Structural Integrity

Reference:
106 High St.
Portland, ME

Structural Integrity Job Number: 13-0121

ATTIC FLOOR PLAN

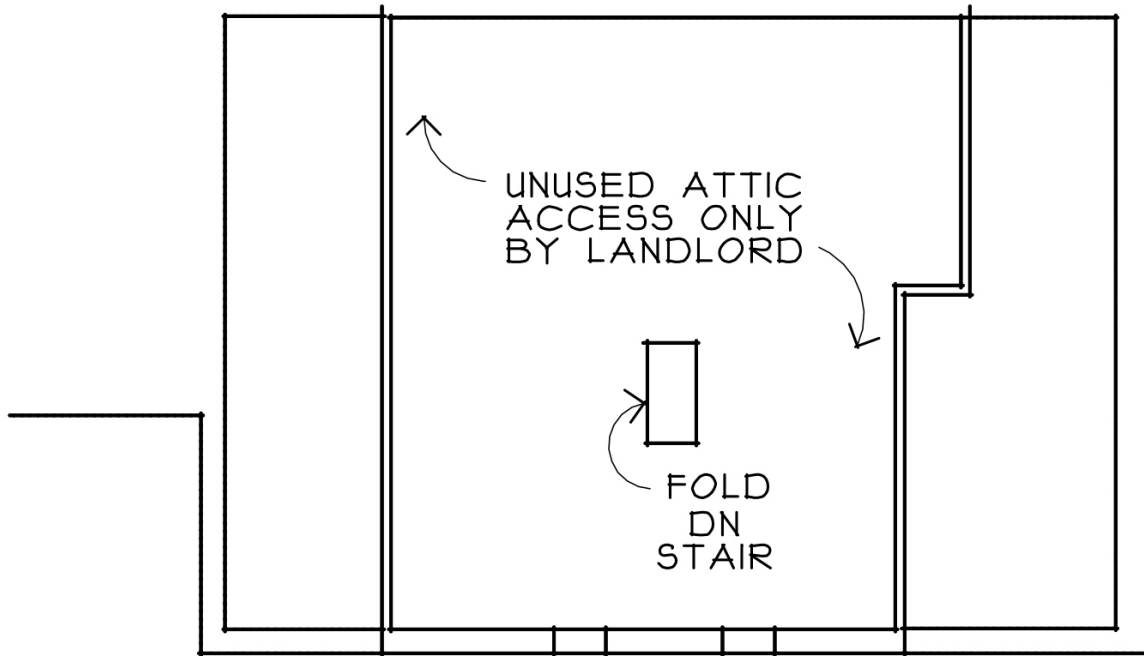
Based on my site visit, I have concluded that it is okay structurally to remove the attic framing as long as the two main timber beams that extend from gable end to gable end remain.
